**First Corporate Shipping Limited
trading as The Bristol Port Company**

**Comments on Applicant's responses to
Examining Authority's first written questions
and request for information
(ExQ1)**

**Application by North Somerset Council for an order granting development
consent for the Portishead Branch Line – MetroWest Phase 1**

**Planning Inspectorate reference TR040011
Unique reference PORT-S57657**

ACCESS POINT
AW 5.1

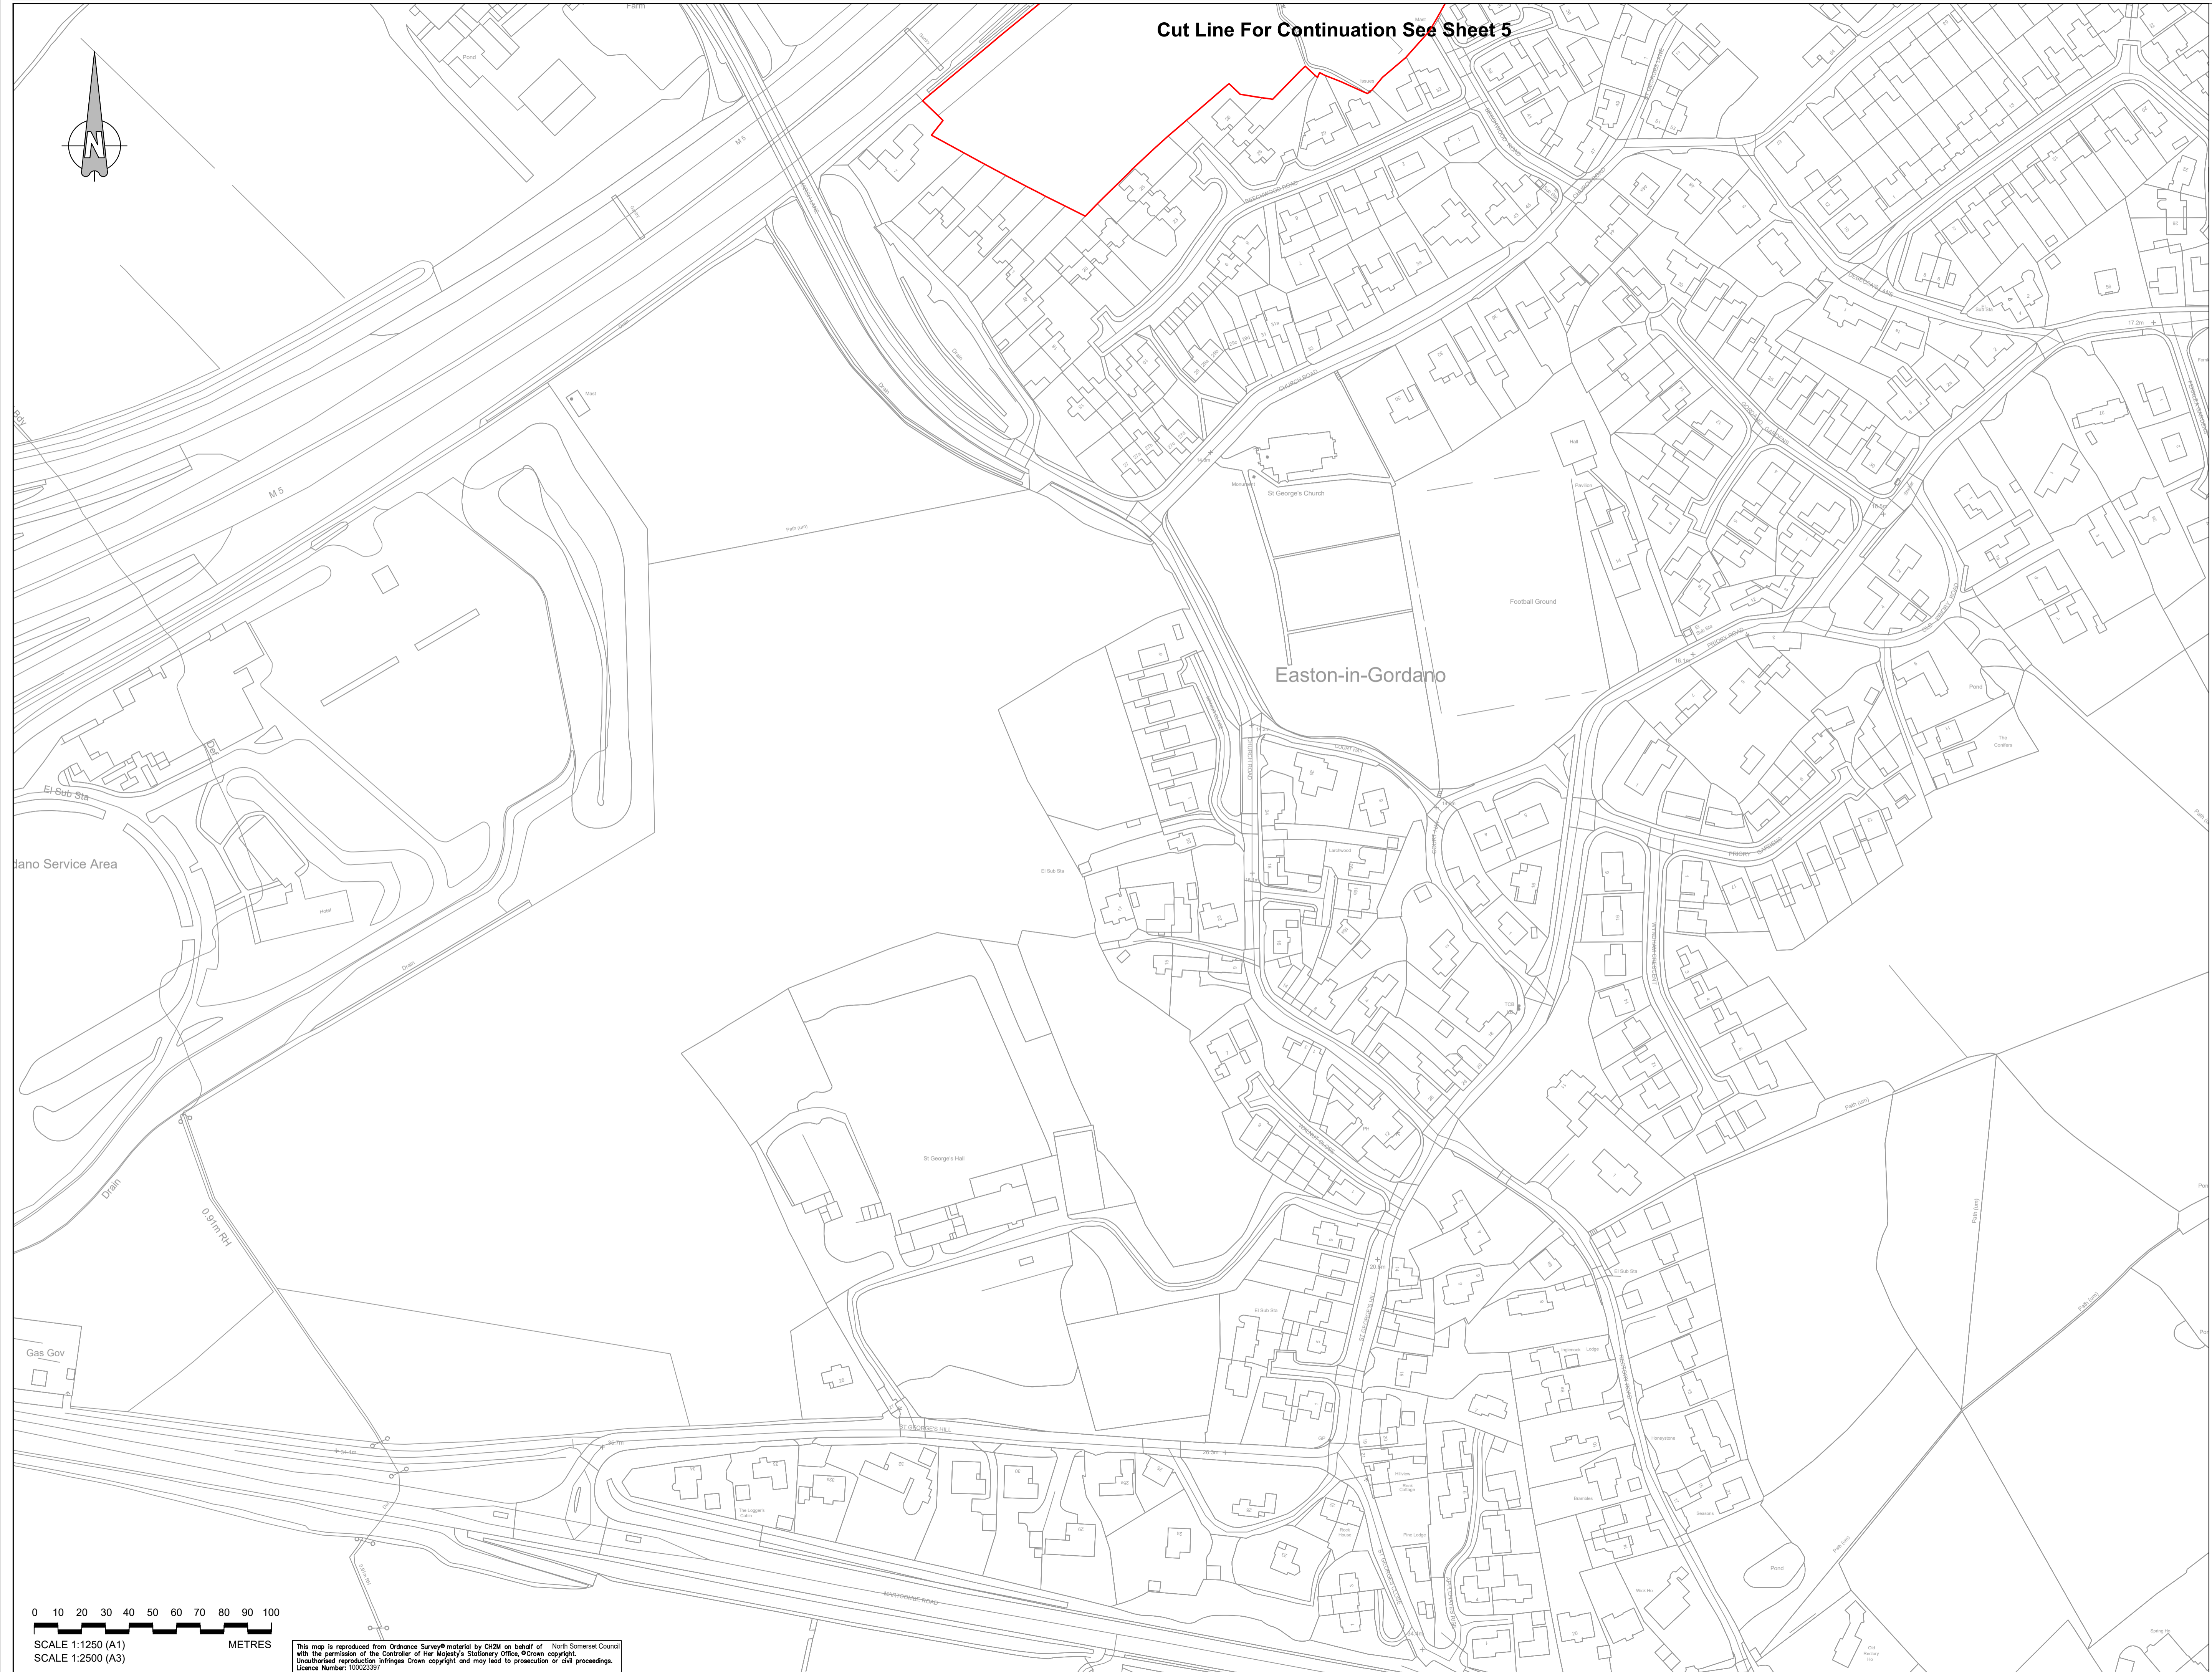
<p>out. Clearly these works, and any others which may be proposed, will affect the ability of others to use the track.</p> <p>In its reply to ExA's question Cl. 1.8 the Applicant states "<i>It is anticipated that large or heavy vehicles gain access to the Lodway Farm compound via access point AW 5.1 shown on the Compounds, Haul Roads and Access to Works Plan (APP-024 and DCO document reference 2.29) and the haul road, and thus not generally using access points that involve routeing through Easton In Gordano. Access to areas of the DCO Scheme in the Pill area can be achieved directly from Lodway Farm compound via access point AW 5.1 and haul road and the railway alignment itself.</i>"</p> <p>This suggests that the track will be subject to frequent use by heavy vehicles moving in both directions. BPC considers that use of that kind would not be possible without works to the track but that carrying out works will impede necessary use of the track by others, including NG.</p> <p>In its response to ExA's question Cl. 1.8, the Applicant suggests that details of use of the track will be left for the contractor to determine during the construction phase, but BPC submits that this is too late a stage to address the question as to the extent of the use of the track which will be possible at all.</p> <p>Given the current lack of sufficient information it is not possible for BPC or, BPC submits, the ExA to assess in the context of the track the extent to which the Applicant's proposals will conflict with the implementation of the Hinkley Point C Connection</p>
